**From:** [REDACTED]  
**Sent:** 22 February 2022 16:49  
**To:** Planning  
**Subject:** OBJECTION to Planning Application 3/2022/0067  
**Attachments:** Property Image.jpg

**EXISTING GARAGE SOUTH EAST ELEVATION**  
Scale 1:100

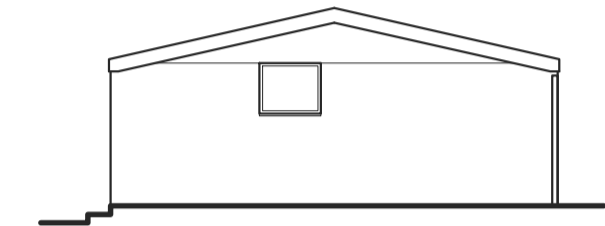
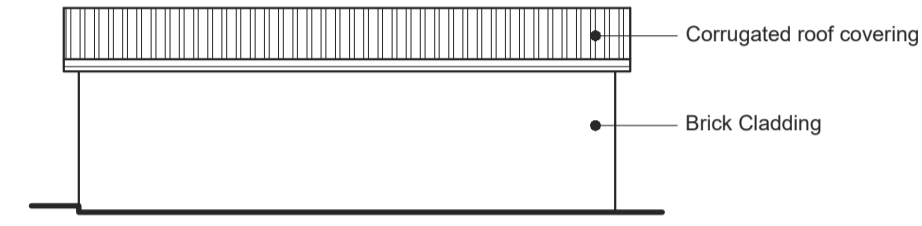
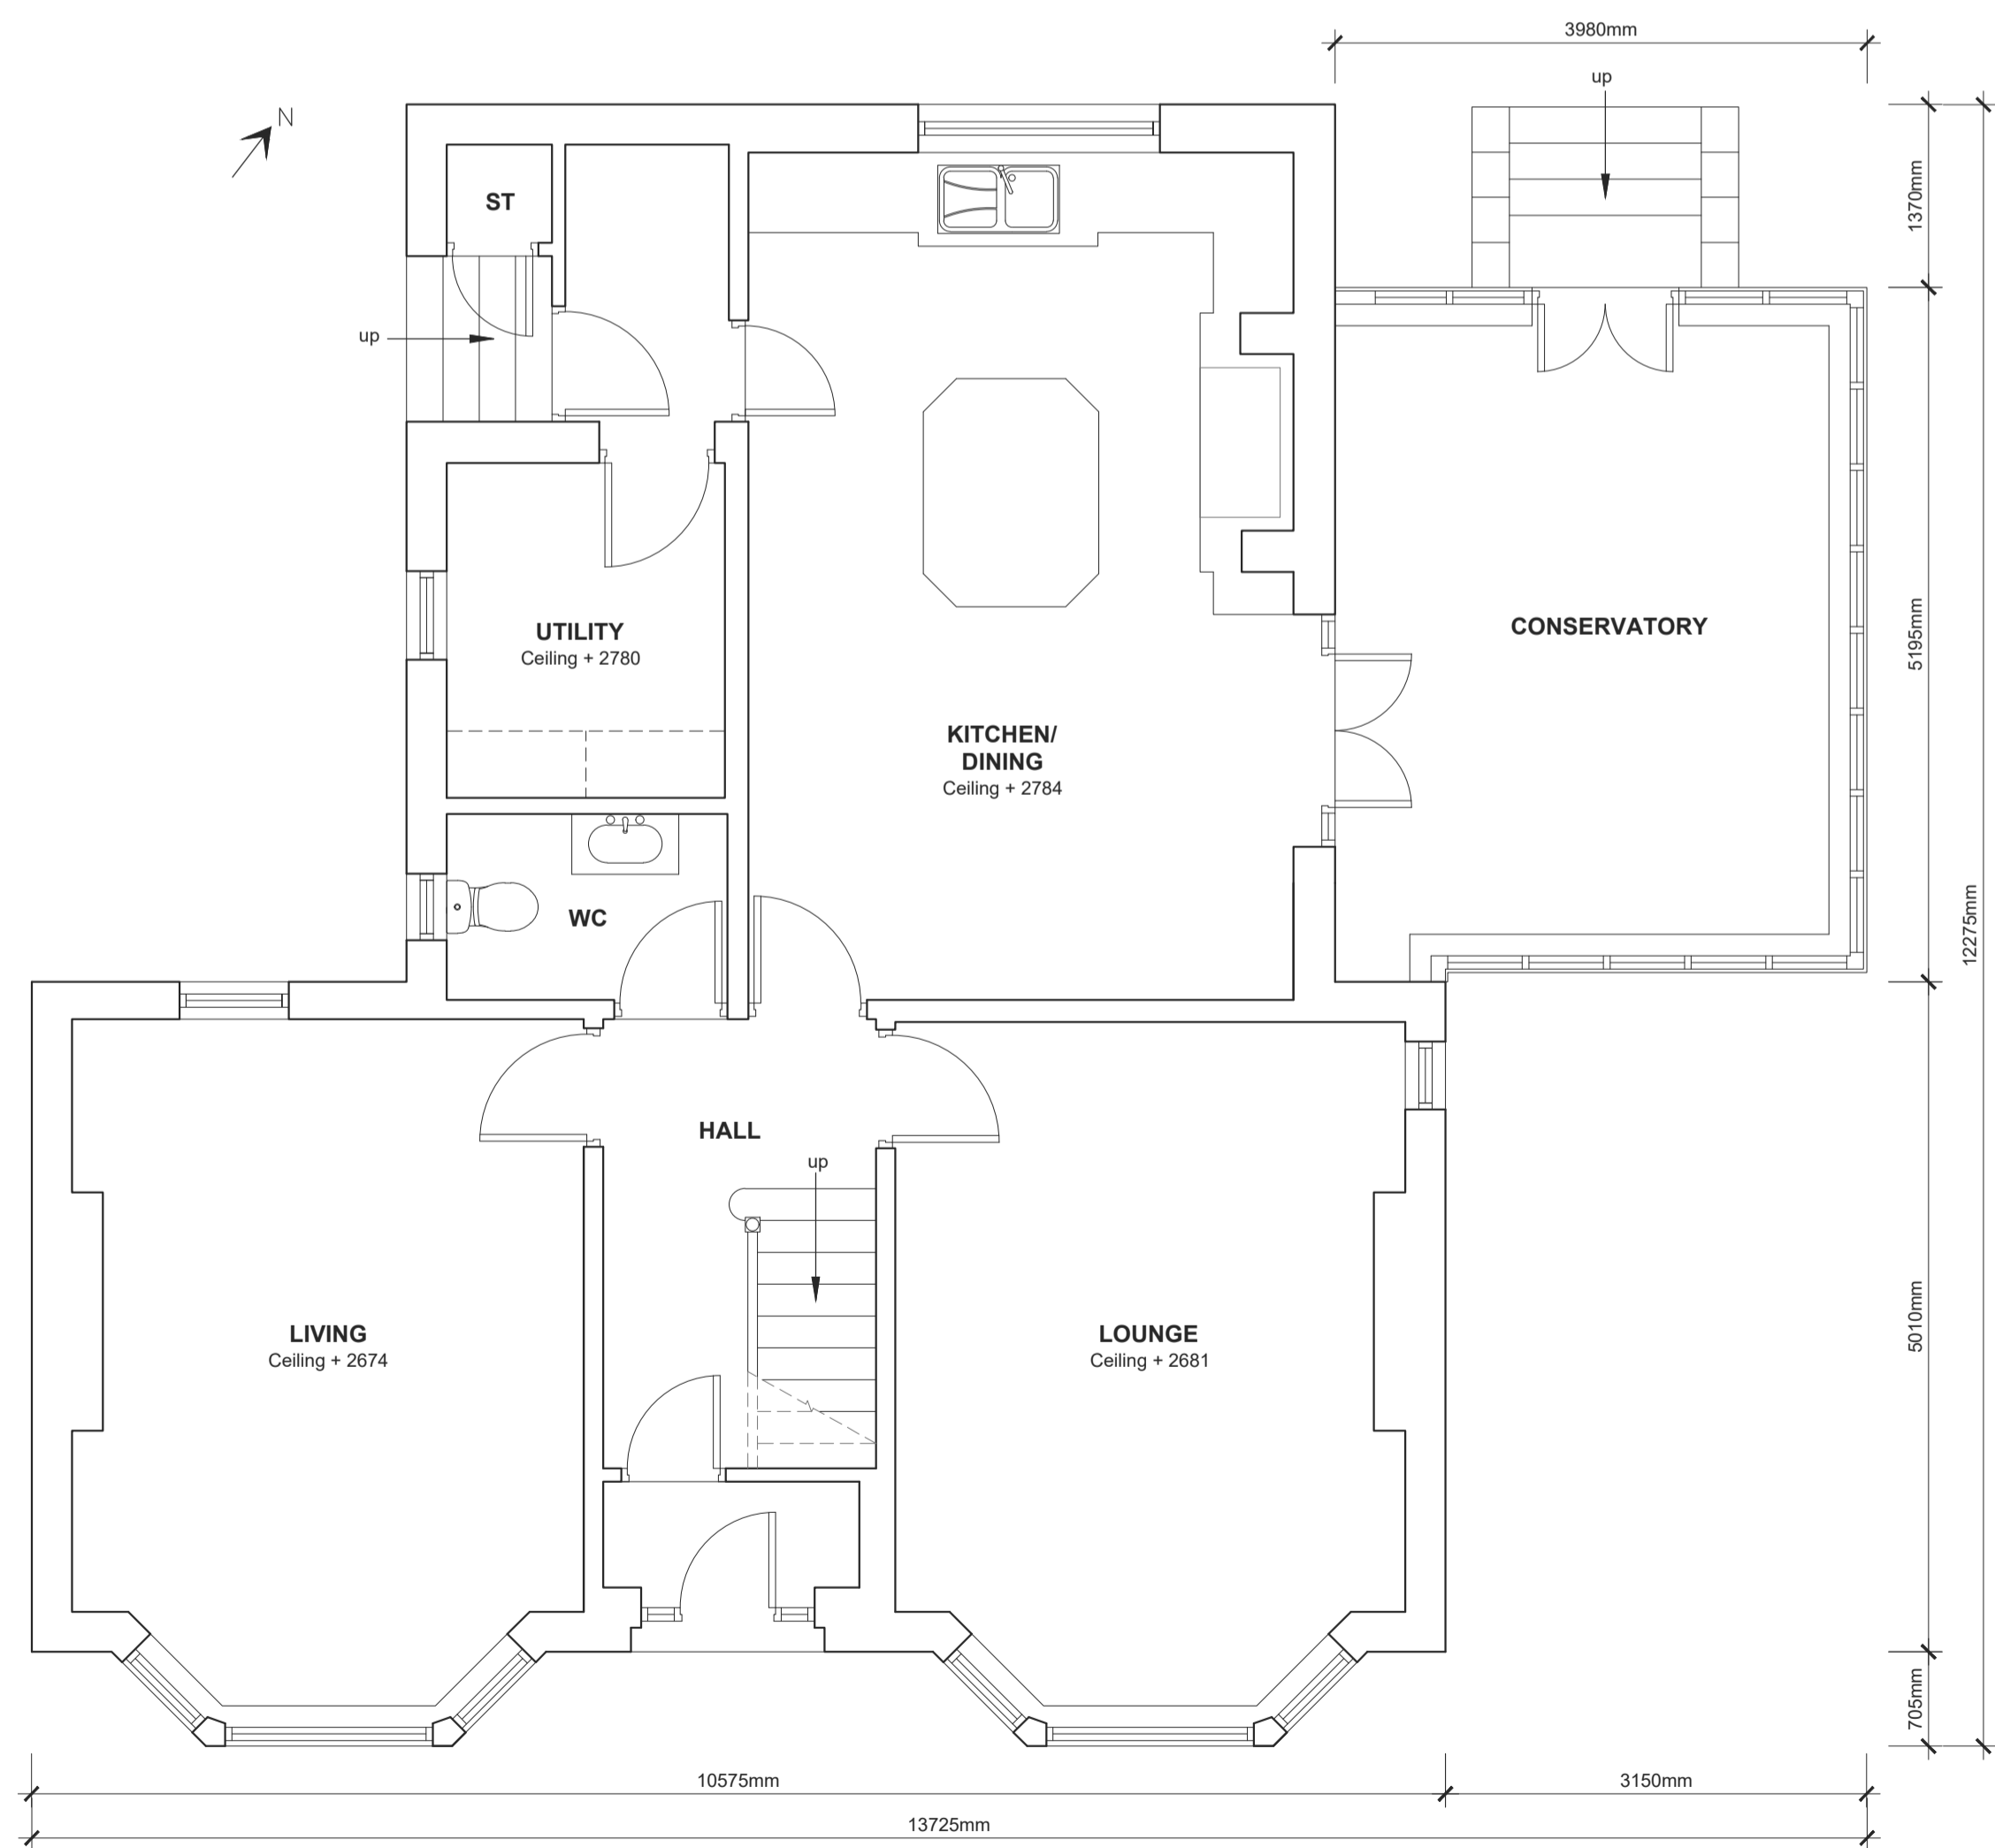
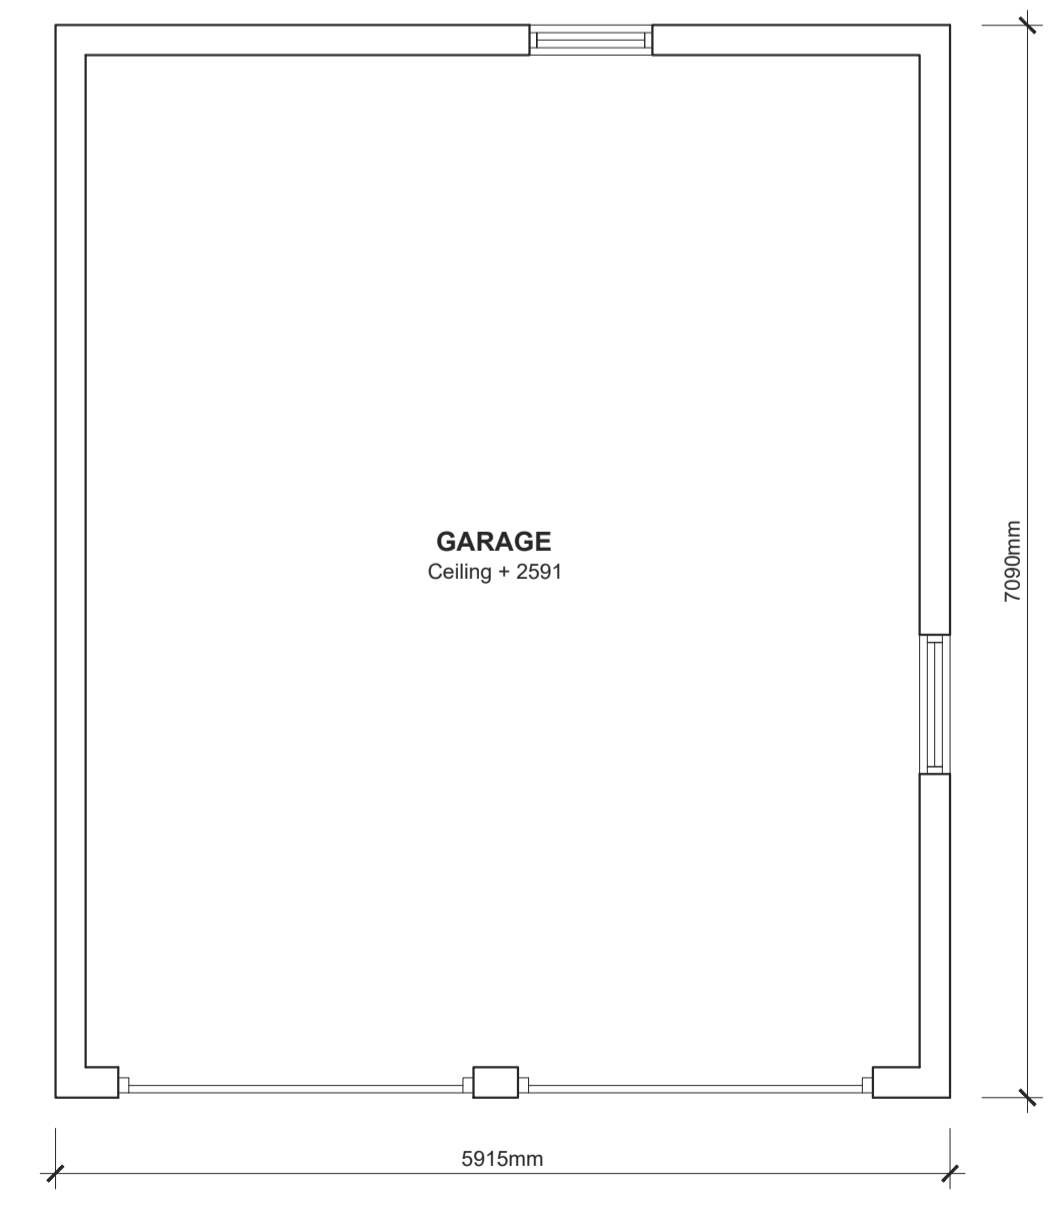
Looking at the plans, the current garage's height is at 2.7m. However the new annex height that is being proposed is at 3.61m- exactly 91cm taller. [REDACTED] (Please see attached photo) making it an eyesore and unappealing from an aesthetic view [REDACTED]. The new elevated height will be [REDACTED]. [REDACTED] I firmly believe this will [REDACTED]. I thus refute point 3.6 in the proposed plan as a 33% rise in height is certainly not modest.
